From: Peter Cleveland
Sent: 27 March 2014 08:35
To: 'James Neave'
Cc: Nat Slade
Subject: RE: WSCC/096/13/F - Ford Waste Treatment Facility - Further Information
Attachments: Local_Plan_Sub_Committee_Agenda_Revised_27_March_2014.pdf; SHLAA Site 71 Extract.pdf

Thank you for consulting the District Council on the further information that has been received relating to the proposed Ford Waste Treatment Facility, your ref: WSCC/096/13/F.

REVISION			
PROJECT		Proposed conversion of Grain store building, Ford Airfield	
SUBJECT		Block Plan and Location Plan	
SCALE	DATE	DRAWING No.	
1:1250 & 1:500	Feb 2011		
DRAWN	CHECKED	11 / 09 / 03

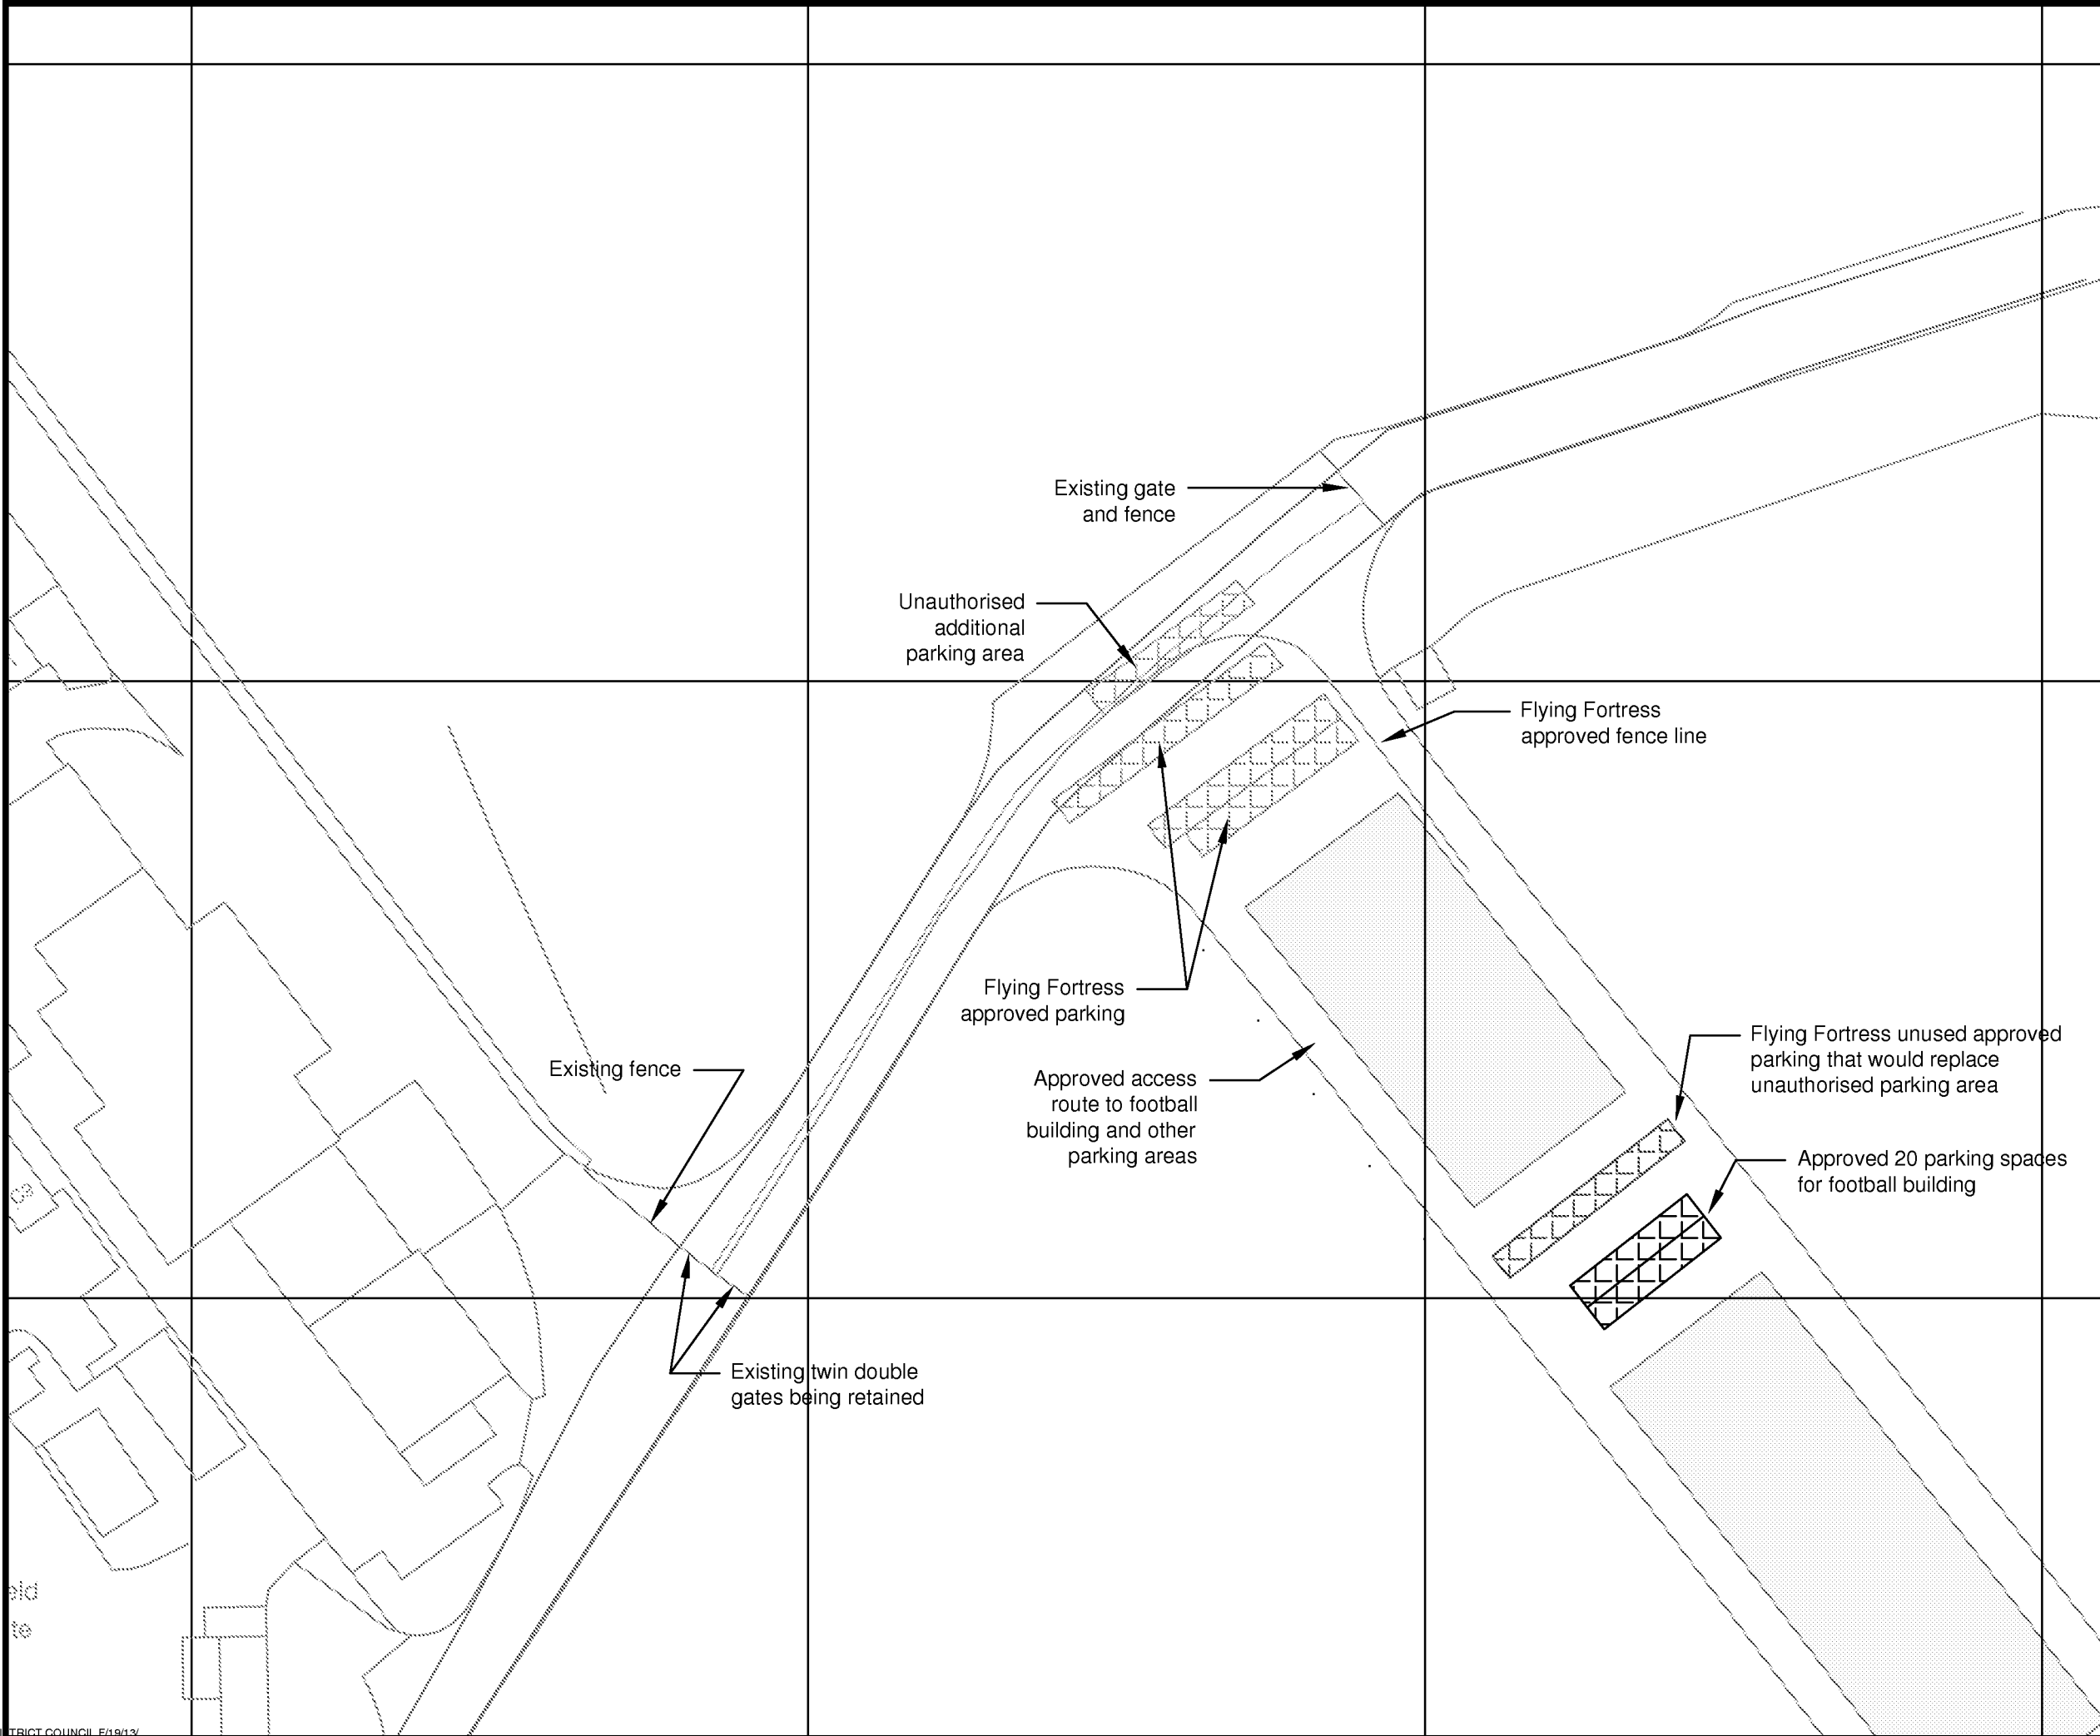
I can confirm that drawing No. 10353/021 approved under F/1/04 identifies the approved parking layout for the Flying Fortress, and drawing number 11/09/03 approved under F/5/11 is the approved parking layout for the indoor football facility.

I have discussed the issue of parking provision and the restriction it imposes upon the access into the waste facility site with colleagues within our enforcement team. Given that the existing parking arrangement for the flying fortress has been in place since the use commenced (March 2005) the Council would not seek to regularise this position. It is my colleagues view that the approval of the indoor football use did not affect the existing parking arrangements for the Flying Fortress which was already established at the front and side of the site. I have also noted the comments in the letter from Flying Fortress stating that parking is lost to the side of the building to allow service/delivery vehicles to the rear, this needs to be addressed by the operator/owner of the site to ensure they can provide the appropriate level of parking and access for the existing use.

It is our view that the parking issues should be addressed by the land owner to ensure that suitable access and parking can be accommodated for both of the sites. I would therefore confirm our position that we would not be taking enforcement action against the existing parking layout.

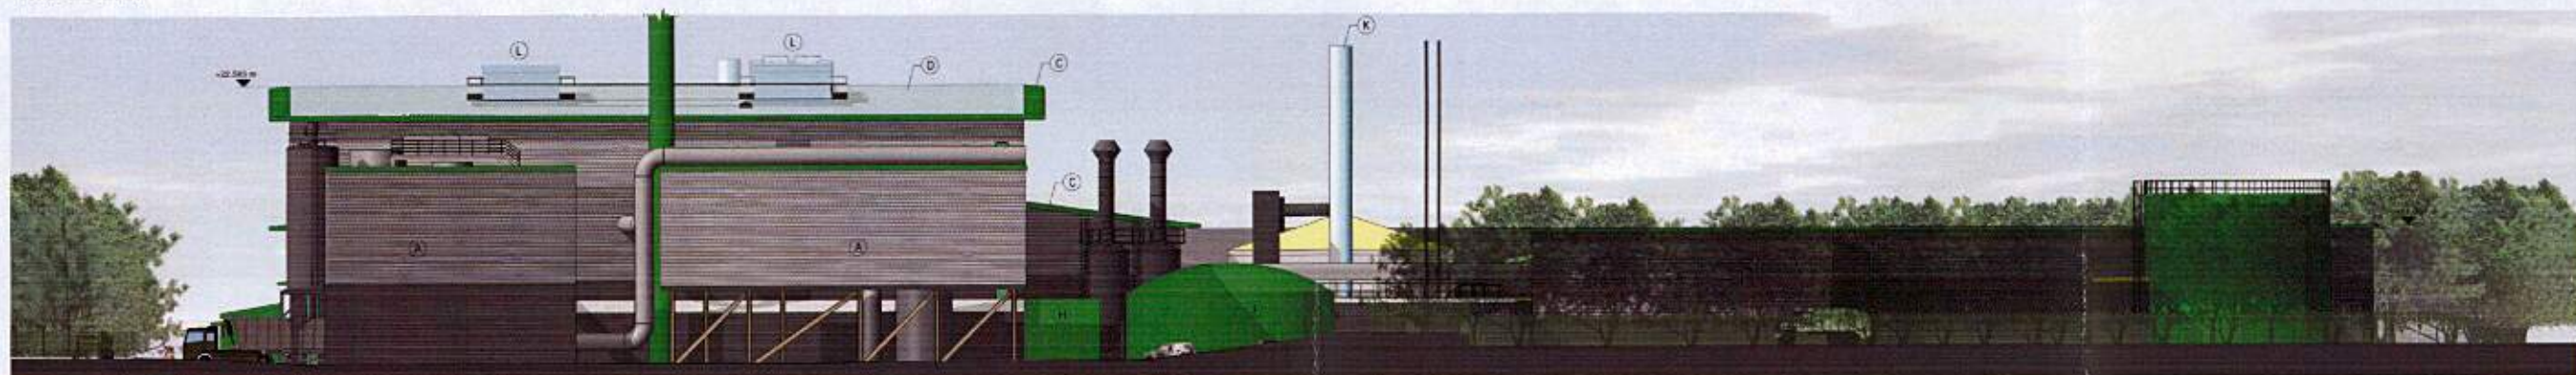
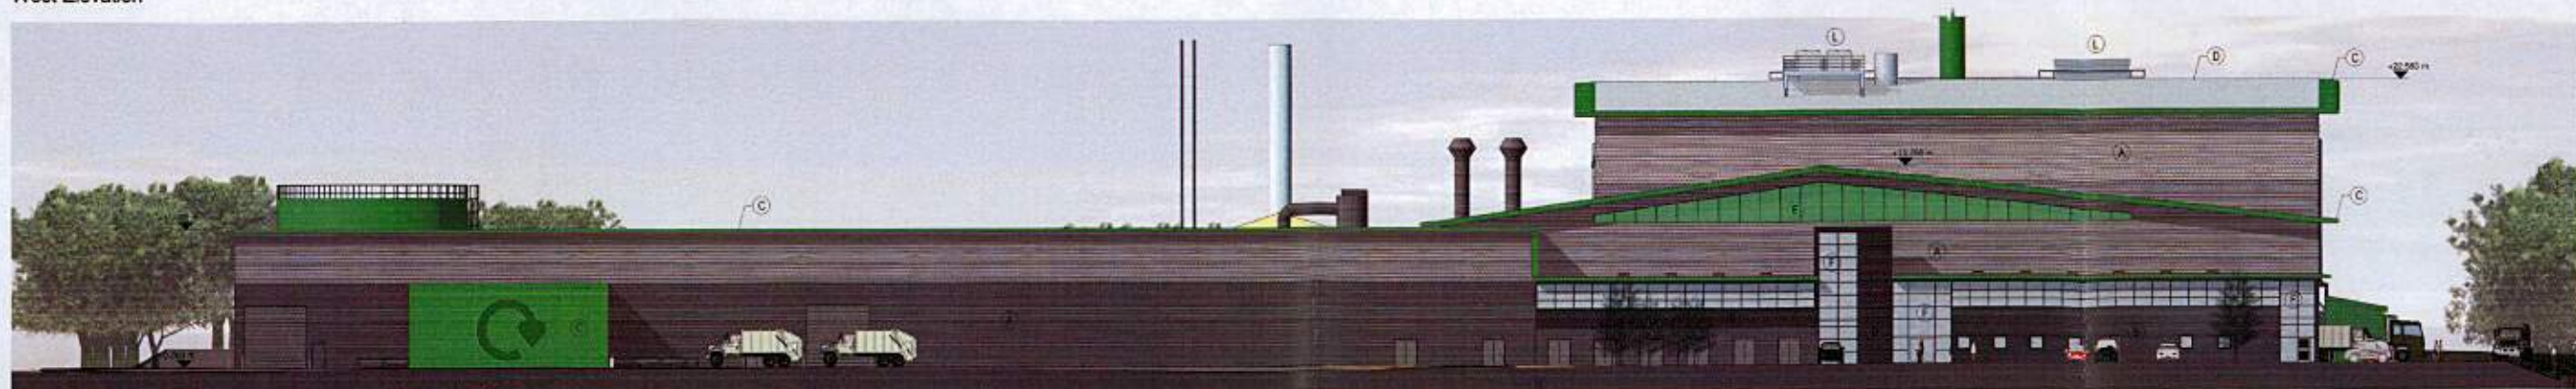
Thank you for highlighting the further information regarding the stack height, I note the comments made from paragraph 5.3 which satisfactorily addresses the district concerns over the justification of its height. There is still concern that there is a visual impact as a result of 50m high stacks, however with the justification given to ensure that air quality impacts are significant reduced by choosing the stack height of 50m rather than 45m the District would except the visual impact.
